PCC has provide comments on some responses provided to ExQ2 at Deadline 7 in the below table.

TITLE: Figure 15.50: Indicative Landscape Mitigation Plan (Landfall)

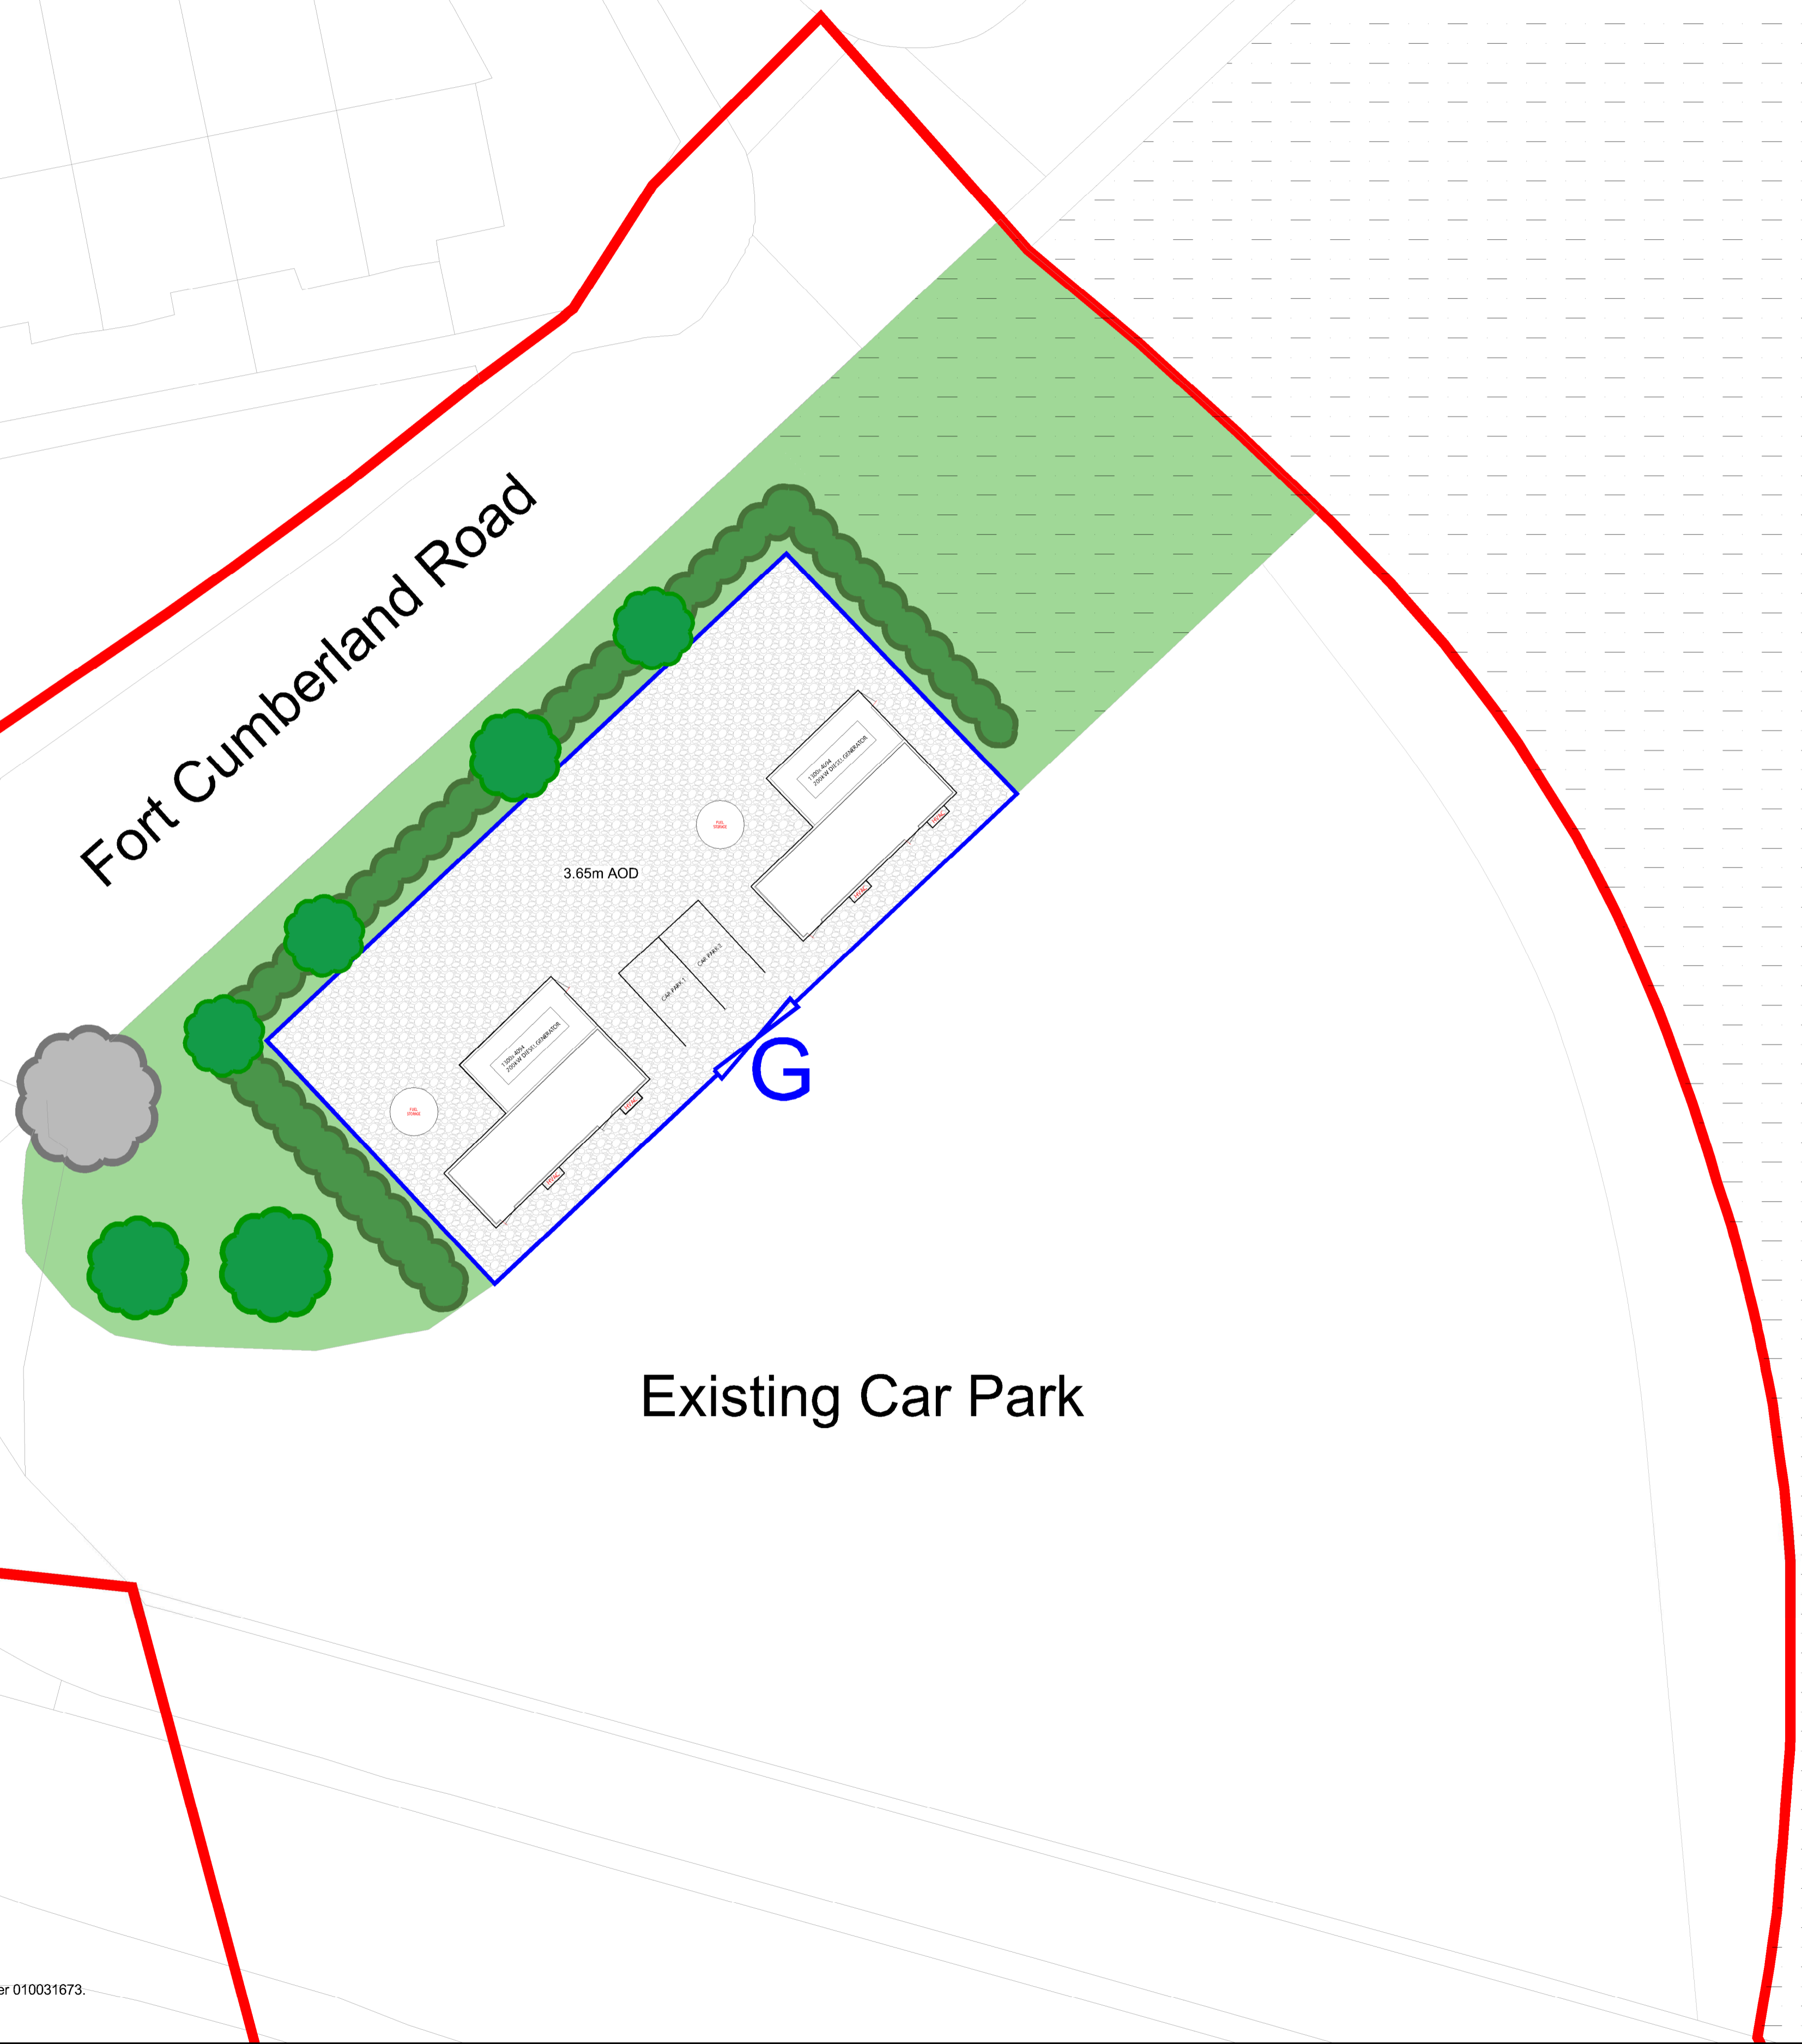
<p>(iv) Thorpe Marsh Gas Pipeline DCO - a guarantee agreement, Escrow arrangement, bond or other suitable alternative security to cover estimated Compulsory Acquisition costs ([REP6-138], Section B paragraph 21 and Section G paragraph 4b).</p> <p>(v) Manston Airport DCO – a section 120(3) PA 2008 provision that construction cannot commence, and Compulsory Acquisition powers cannot be exercised until a guarantee to pay compensation under the DCO or an alternative form of security is provided to the satisfaction of the Secretary of State ([REP6-138], Section G paragraph 4c).</p> <p>(vi) Wylfa Newydd (Nuclear Generating Station) dDCO - dDCO articles restricting the exercise of Compulsory Acquisition powers until certain compensation funding security requirements are met ([REP6-138], Section G paragraph 4d).</p>		
CH2.4.1	Historic England Hampshire County Council Applicant	<p>With reference to paragraph 5.6.12 of NPS EN-1, what elements of cultural, historical and functional significance for Fort Cumberland’s setting are derived from the ‘fields of fire’? How do these elements:</p> <p>a) apply to the land where the ORS facility is proposed to be located; and</p> <p>b) apply to the land where proposed landscape mitigation is to be planted?</p> <p>How would the Proposed Development affect such significance and the future value and understanding of the asset? Would mitigation planting itself affect the significance of the asset’s setting?</p>	<p><i>With reference to paragraph [5.8.12] of NPS EN-1, what elements of cultural, historical and functional significance for Fort Cumberland’s setting are derived from the ‘fields of fire’?</i></p> <p>RESPONSE FROM APPLICANT:</p> <p>"With regard to Overarching National Policy Statement for Energy (EN-1), the Applicant assumes that the correct paragraph reference is 5.8.12, rather than 5.6.12 which relates to dust, odour, artificial light, smoke, steam and insect infestation (Section 5.6) rather than Cultural Heritage.</p> <p>Elements of the ‘fields of fire’ which contribute to the significance of Fort Cumberland are the sightlines and connectivity with land and sea-based approaches along with historic relationships with other fortifications and approaches. The position of the fort is important to understanding how it would have defended Langstone Harbour in the event of an attack. It had direct lines of sight out to sea and was also protected by a ravelin on its western side which defended the landward approaches (ES Chapter 21, para 21.5.11.8). The existing coastal plain which forms part of the fields of fire to the west of the asset makes a contribution to the significance of the fort and so do the sightlines from positions to the north, east and south of the monument (landward/seaward), of which the combined contribution increases understanding of the Fort’s functional significance.</p> <p>This in turn allows the public to understand and appreciate the heritage significance of the fort. These sight lines are</p>	<p>PCC maintains concerns, raised in previous submission that the impact on Fort Cumberland's setting and the local heritage and open landscape will be unacceptably harmed by the proposed unjustified and disproportionate ORS compound.</p>

<p>still evident and contribute to its significance but to varying degrees.</p> <p><i>How do these elements: a) apply to the land where the ORS facility is proposed to be located; and b) apply to the land where proposed landscape mitigation is to be planted?</i></p> <p>a) The contribution of the land where the ORS facility is proposed to be located is diminished by its present use as a car park, with its associated height restriction barriers and constant movement of traffic, in addition to the visually intrusive surrounding urban fabric, which has been substantially altered through the construction of a 1960s housing estate (located 15m north of the Proposed Development) and 20th century motor shed adjacent to the north. Due to the surrounding modern development, the existing contribution of the landfall car park on the significance of Fort Cumberland is considered low. As a result, the historic 'fields of fire' is at present poorly understood.</p> <p>b) The proposed landscape mitigation planting is contained within the Order Limits at the Landfall. As shown on the Indicative Landscape Mitigation Plan (Landfall) Figure 15.50 (APP-283), planting is proposed around the boundary of the ORS facility in the form of a native hedgerow with hedgerow trees; existing grassland/scrub to the north-east would be reinstated. The contribution of the current land to the historic 'fields of fire' is low, given the present use as a gravelled carpark."</p> <p><i>How would the Proposed Development affect such significance and the future value and understanding of the asset?</i></p> <p>RESPONSE FROM APPLICANT: "The Applicant's position with regard to the impact assessment is outlined in the latest revision of the Statement of Common Ground (SoCG) with Historic England submitted at Deadline 7 (REP6- 047, Rev 005). The Applicant considers the impact to the significance of Fort Cumberland is negligible in respect of views from the western ravelin, based on the distance from the asset and the presence of the car park and the visual impacts from the modern residential housing estate located 15m to the north-west of the proposed ORS</p>

<p>compound. The Applicant considers that the landward view from the western ravelin has been substantially altered.</p> <p>The location of the proposed ORS compound would introduce a new built form in long views out from the western ravelin towards Fort Cumberland Road. However, the proposed ORS would be lower in height than the current housing estate, and when seen against the background of the surrounding residential development would not be visually intrusive. Taken overall, the ORS would not have a significant impact on how the asset is appreciated and understood. The overall environmental effect is therefore considered negligible.</p> <p>It has been agreed between the Applicant and Historic England that the proposed ORS would not result in substantial harm to the Fort Cumberland Scheduled Monument and Grade II*listed building (REP6-047, Rev 005). Historic England maintain that the level of harm is less than substantial, whilst the applicant considers the overall effect to Fort Cumberland scheduled monument is negligible. Irrespective of this differing professional opinion, the proposed change would not constitute a 'significant' environmental effect warranting substantial design amendments to the Proposed Development."</p> <p><i>Would mitigation planting itself affect the significance of the asset's setting?</i></p> <p>RESPONSE FROM APPLICANT: "The settings assessment has considered the potential for impact in relation to the embedded landscape mitigation. The predicted impact is considered negligible in respect to Fort Cumberland (see above). The embedded landscape mitigation planting would not form any additional impact to the significance of the asset as the proposed changes would not alter the baseline urban setting in which the ORS would sit, which at present includes modern 1960s development and a line of mature trees, bounding a caravan park to the west of the landfall car park. As with the ORS buildings themselves, the overall change to the fort and its wider construction is negligible."</p>
